23 November 2022

TfNSW Reference: SYD19/01350/50

Departments Reference: SSD-10448 – MOD 3

**AMMENDED APPLICATION - SECTION 4.55 MODIFICATION TO ASPECT INDUSTRIAL ESTATE,
WAREHOUSE 9 - 804-882 MAMRE RD, KEMPS CREEK**

SSDA-MOD 3
ESTATE MASTERPLAN
DATE: 28.07.22 SCALE: 1:4000 @ A3 21/250 MP5-02 A

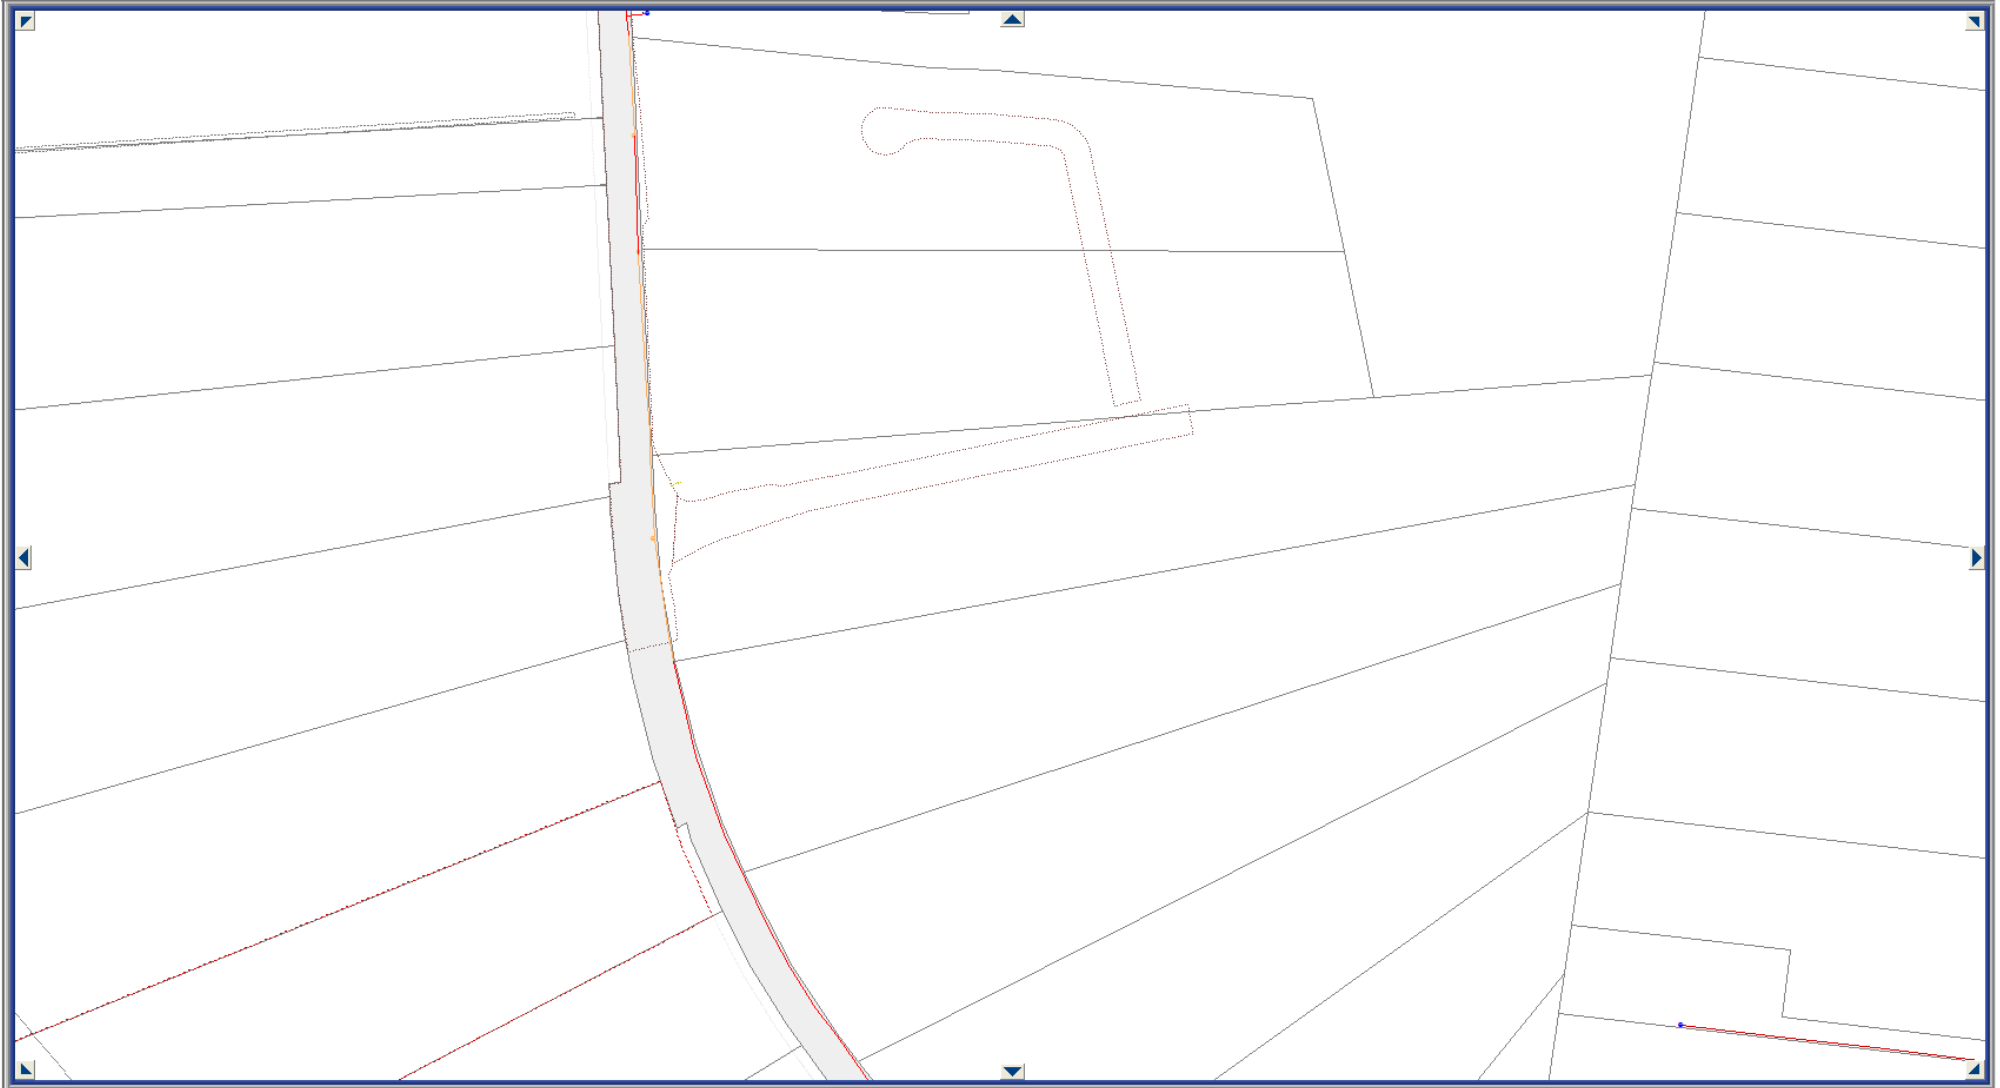
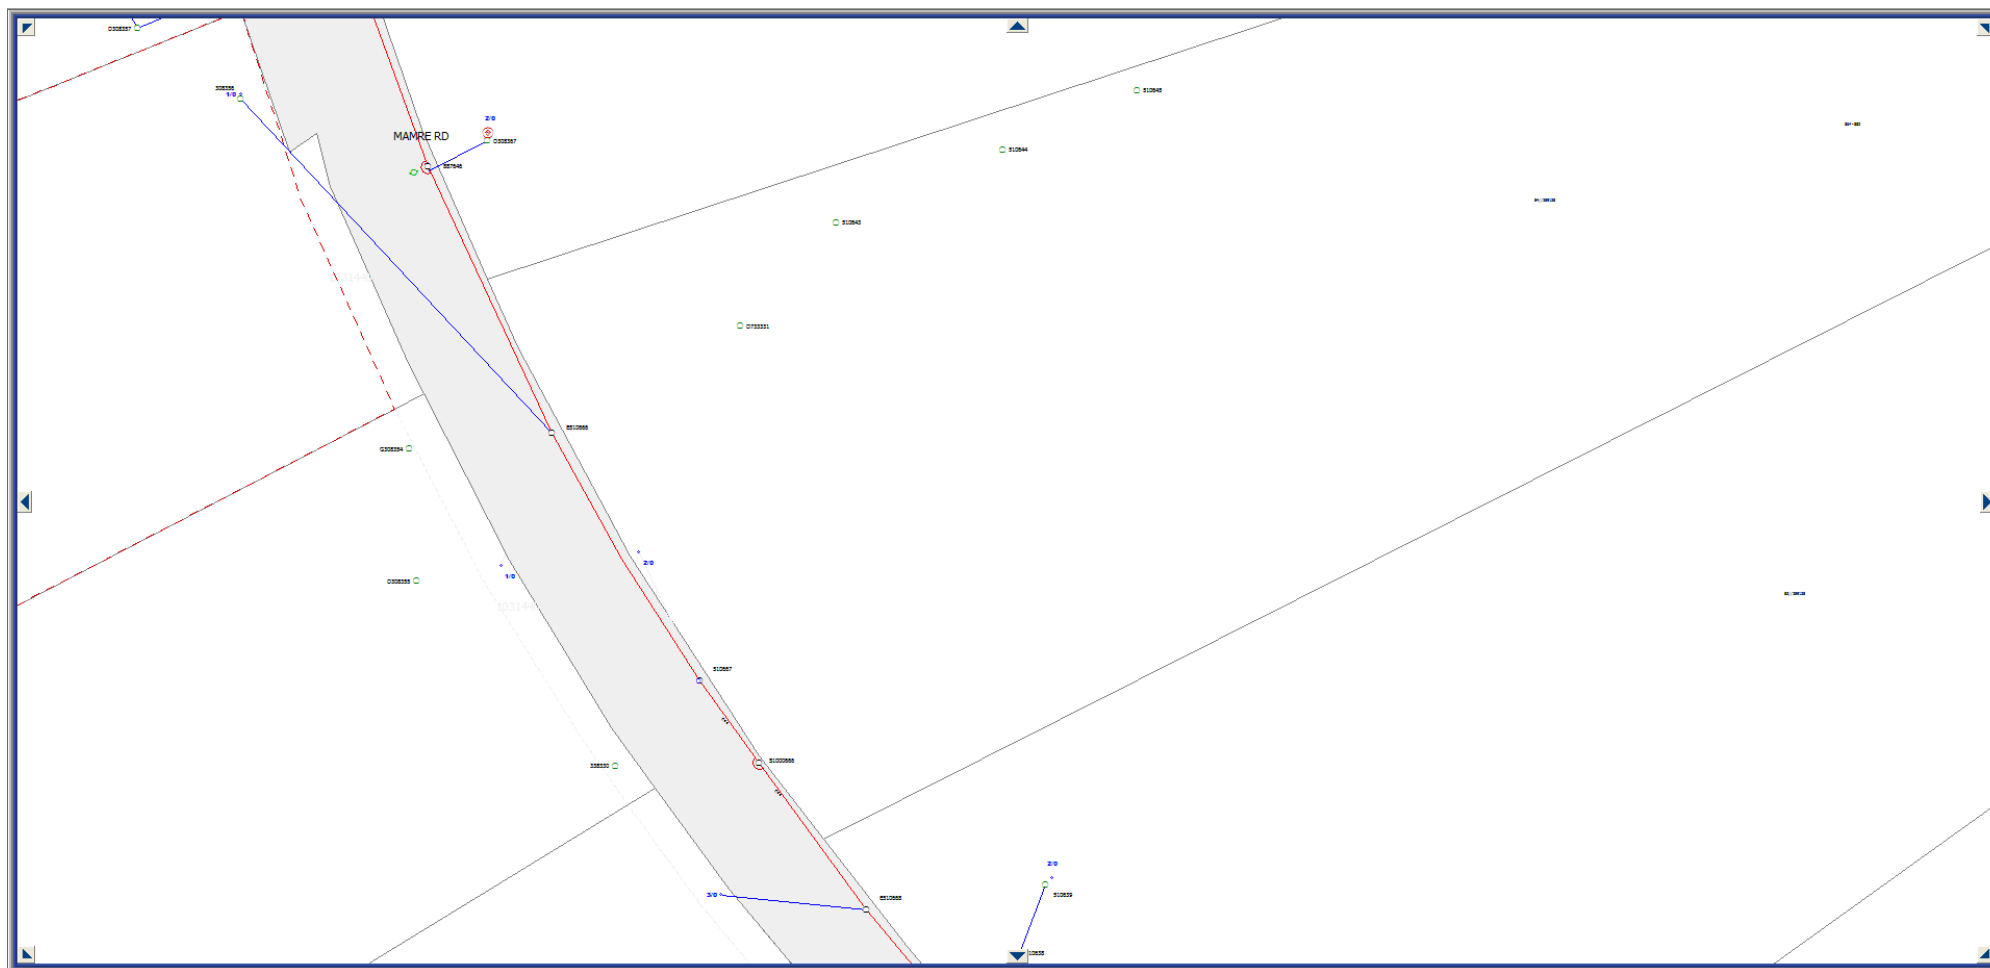
The Concept Masterplan depicts the Access to Warehouse 1 with a declaration lane within close proximity to the signalised intersection. It is understood that this access arrangement is being addressed in Modification 2 application. Therefore, TfNSW is of the understanding that the issues relating to this access will be addressed under Modification 2 and not be included as part of this application.

It is noted that the Modification includes relocating access points along Access Road 1 and 3 from Warehouse 1,2,3 and 6,7,8. It is strongly recommended that were possible accesses to Warehouses are not from collector roads. This is recommended to reduce congestion and conflict points along collector roads to ensure the most efficient network is developed.
